| PROJECT REF: | LD10848 |
| TECHNICAL NOTE REF. | LD10848-0009 |
| SUBJECT: | Clarification Note for Barnsley Metropolitan Council – Arboriculture |
| DATE: | 21 st May 2024 Revised 17 th June 2024 |

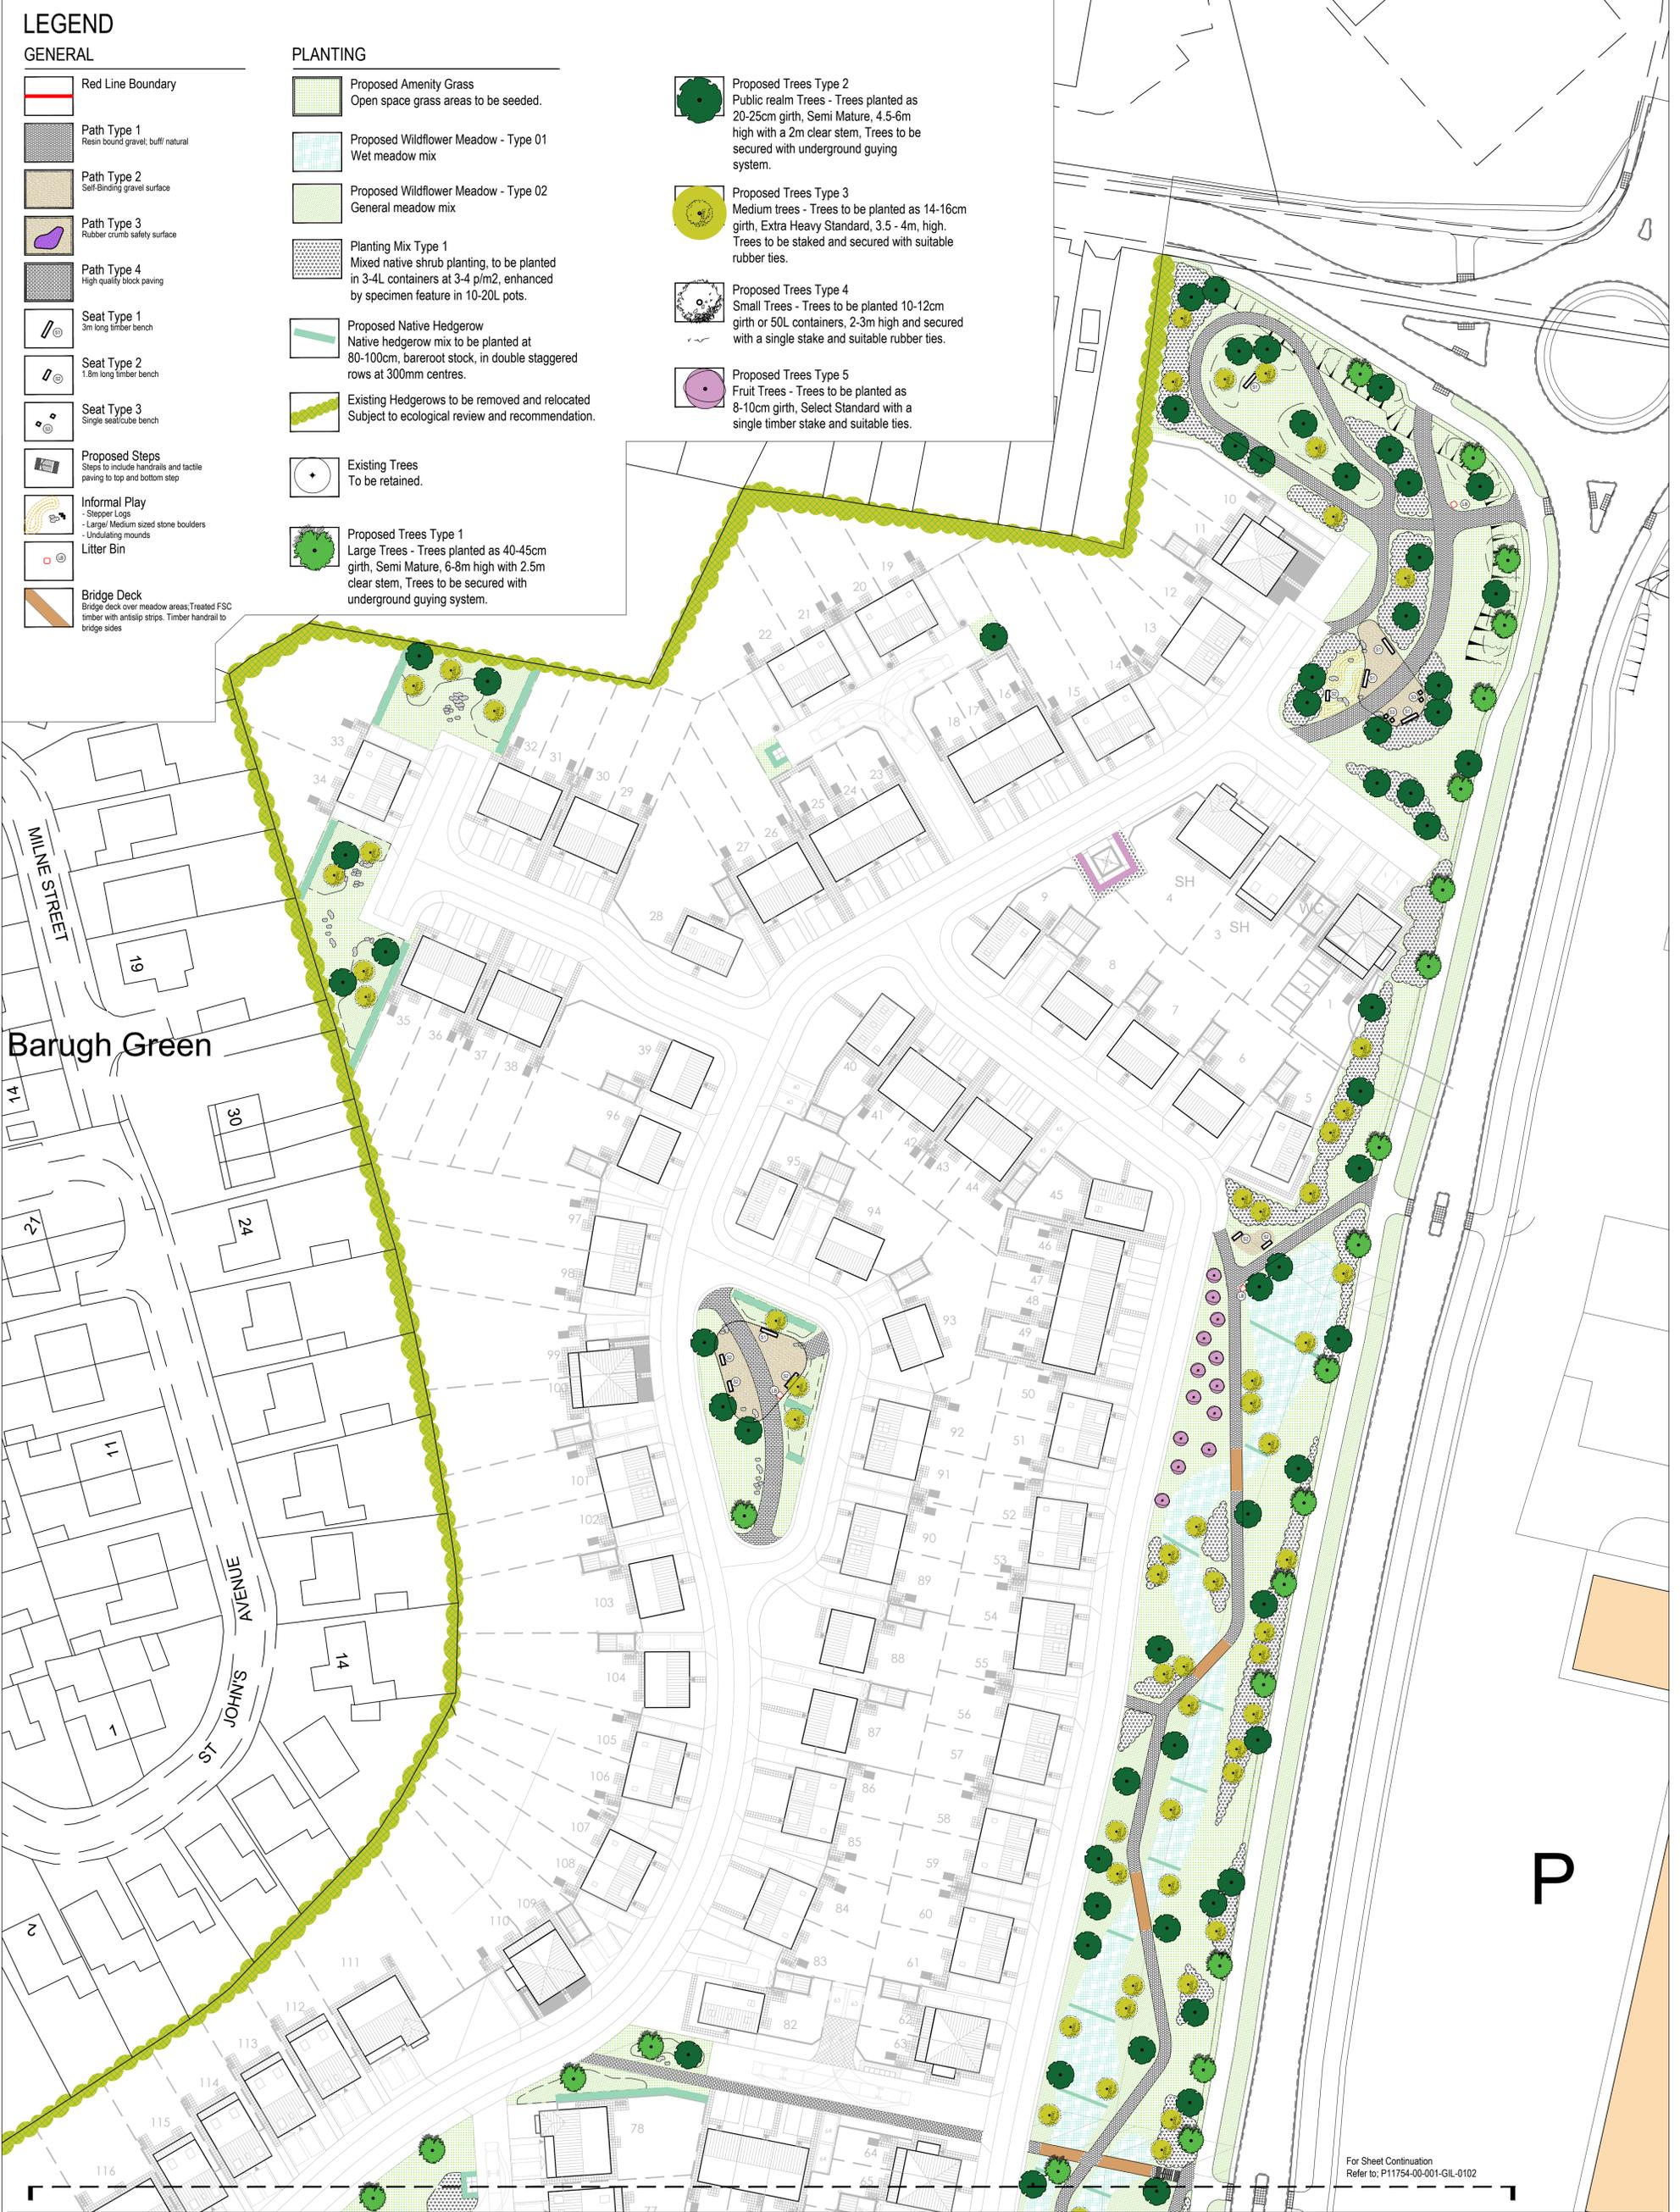
- 2.1 We note the Council’s comments with regard to the potential for direct impacts to the AWs Ref. W1a and W1b. The comments from the Council are as follows:
 - *‘Clarification is required following further survey work to establish the least damaging methods of installing the surface water drainage outfalls within the AW buffer zone and AW.*
 - *Amendments required to provide Flexipave to all the routes through the ancient woodland’;*

- 2.14 A new pre-cast concrete headwall (Althon SFA10C Headwall/ Althon SFA6C Headwall) will be placed at the terminus of the HDD outfalls drainage run. The headwalls will be delivered to their final position by either dumper or trailer and manoeuvred into place by the excavator.
- 2.15 Footway locations within the AWs as shown on the TPP Ref. LD10361-030 Rev. D are indicative and their locations will be micro-sited to avoid impacts within the woodland where possible. The footways within woodland W1 will be of a no-dig construction, consisting of a three-dimensional geogrid sub-base such as 'Cellweb'³ charged with 20-40mm clean angular stone, with the wearing course being permeable 'Flexipave'². Please refer to Strategic Landscaping Area Plan Ref. P11754-00-001-GIL-0100 Rev. 10,

latest revision dated 16/05/2024, by Gillespies. The footways' full specifications and installation methodologies can be included in an AMS, which can be conditioned by the LPA. Installing footways in the above-described way is likely to have a low impact on the AWs.
